Epping to Thornleigh Third Track proposal - SSI 5132

SSI 5132

In this second submission, I would like to comment on the Third Track proposal with a view to reducing construction costs and improving service/accessibility to rail commuters. My comments concern Cheltenham and Beecroft stations.

Figure 5.6 Cross-section and elevation - New Cheltenham Station concourse building
Note: Indicatively added to future design

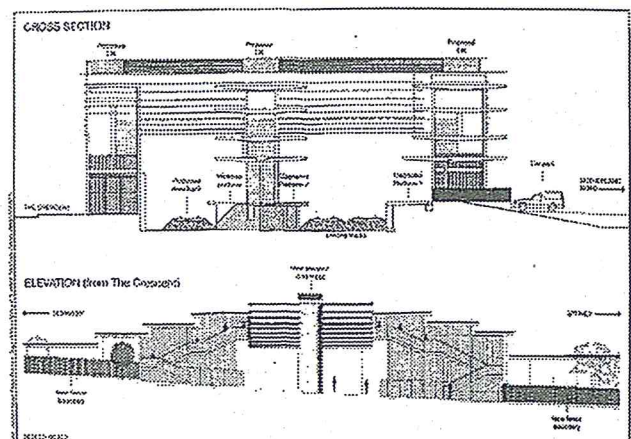
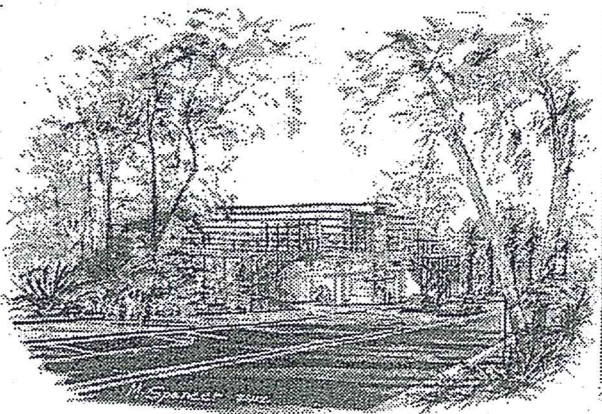
I believe the proposed changes to Cheltenham Station are unnecessarily costly due to the proposed new concourse building with its three new lifts. Substantial savings could be achieved by implementing the same model at Cheltenham as presently exists at Beecroft Station. There is a single between-tracks platform at Beecroft (the eastern side forms the platform to the city and the western side forms the platform to Hornsby). The between-tracks platform is accessed

From the preceding two factors would more than offset the cost of ~~constructing~~ ^{constructing} a pedestrian underpass. An additional advantage would be that justifiable concerns about the visual impact of the concourse building would be overcome.

Concept design drawing of proposed changes to Beecroft Station (Parsons Brinckerhoff 9/3/12). Former side platform shaded in pink.

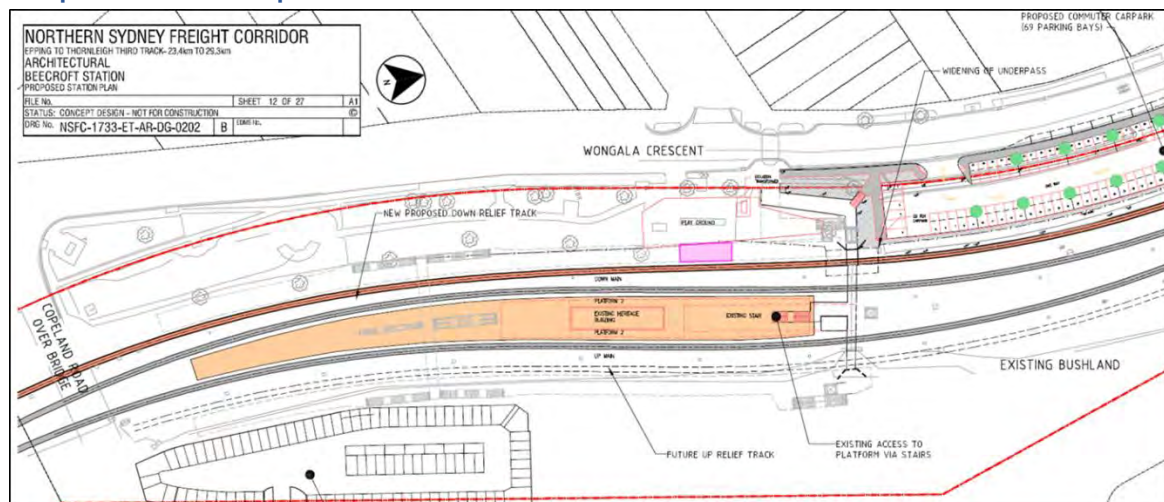
There has been a long-standing need for a lift from Beecroft's pedestrian underpass to the central platform. The matter has become an acute access problem with for the disabled, the elderly, mothers with children in prams, and those temporarily recovering from injury, etc.

Further, if a lift was installed at Beecroft Station during work on the Third Track project, there would be a clear cost advantage — work on the lift could be coordinated with similar work at adjacent stations (Cheltenham and Pennant Hills).

to the Legislative Council of NSW of a petition calling for a lift. The petition was signed by over 2,000 concerned residents. The present access of two flights of 16 steps each is frankly a disgrace.

Beecroft is a much busier station than Cheltenham which, unlike Beecroft, has no commercial precinct and no connecting bus services. It is virtually incredible that it could be proposed that Cheltenham should have three new lifts and Beecroft none.
